From: Laura Gibbons
Sent: 03 May 2019 16:02
To: Simon Davis <Simon.Davis@arun.gov.uk>
Subject: RE: Y/9818/RES and Y/97/18/DOC

Still not happy with the details or the proposed landscaping details. My original comments are shown in blue, the applicants responses are provided in red, and my responses to these are shown in *purple*:

Comments on the revised drainage and landscape proposals:

drawing no: BOV22172 12J sheet 4

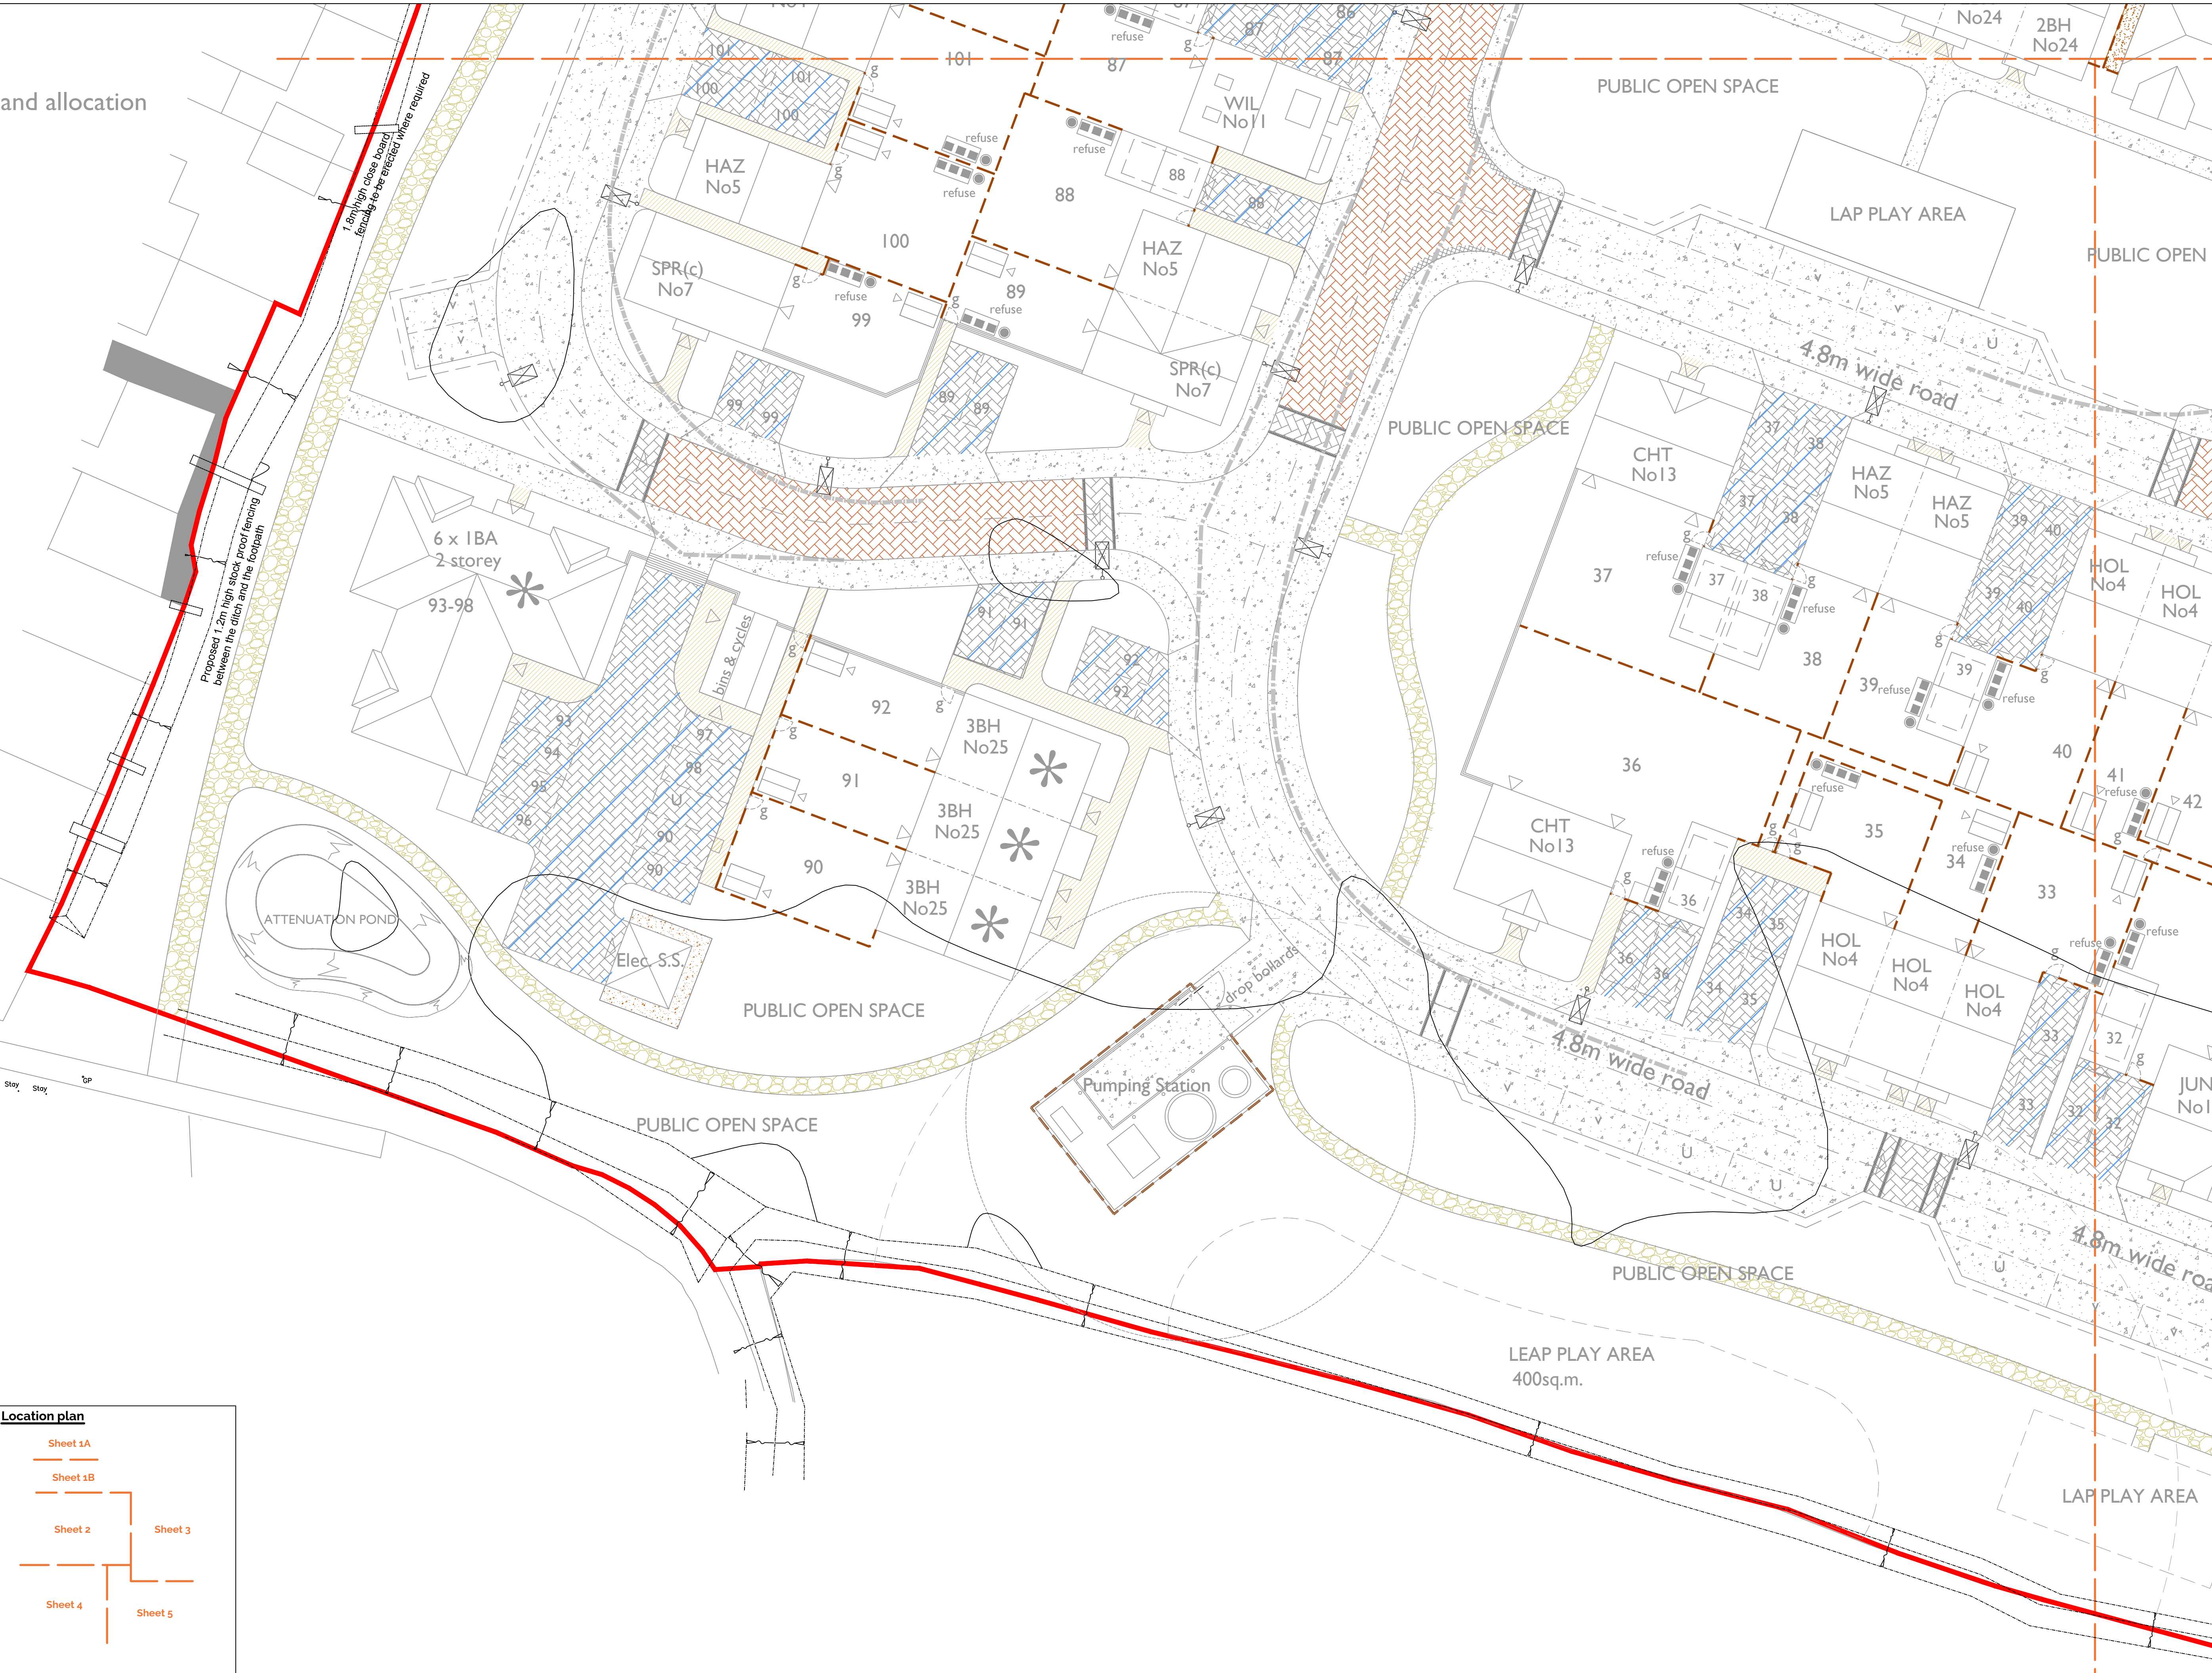
1. There are still trees proposed in close proximity to the southern-most attenuation tank. 2 no. trees close to this tank have been removed. Refer to updated ACD landscaping drawings. *On the ACD landscape drawing sheet 4 revision G there are trees in close proximity to the crate nearest the pumping station. Please can a plan be provided which shows both the proposed drainage and the proposed planting and associated potential root areas on the same drawing.*
